EP/115/17/NMA

Application for a non-material amendment following the grant of EP/48/17/HA to increase roof height.

Description of Approved Development:
 Detached Garden Studio

Drawing
Existing & Proposed Elevations

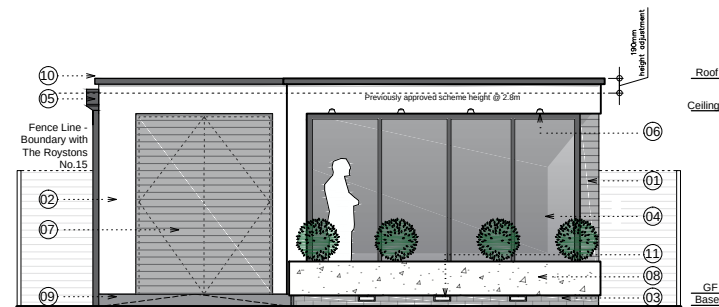
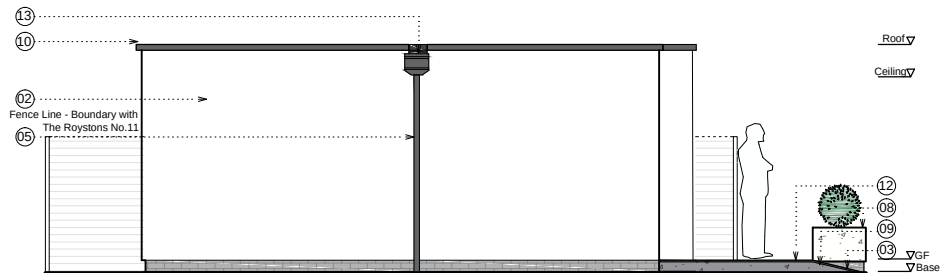
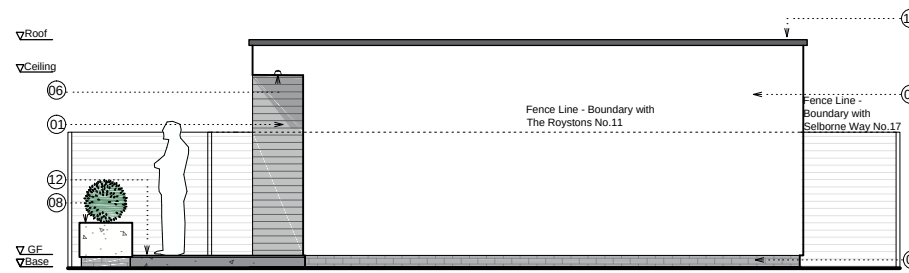
*Please describe the non-material amendment(s) you are seeking to make:
 Increase in roof height of 170mm. Still no higher than 3m.

Floor construction and insulation method to comply with building regulations.
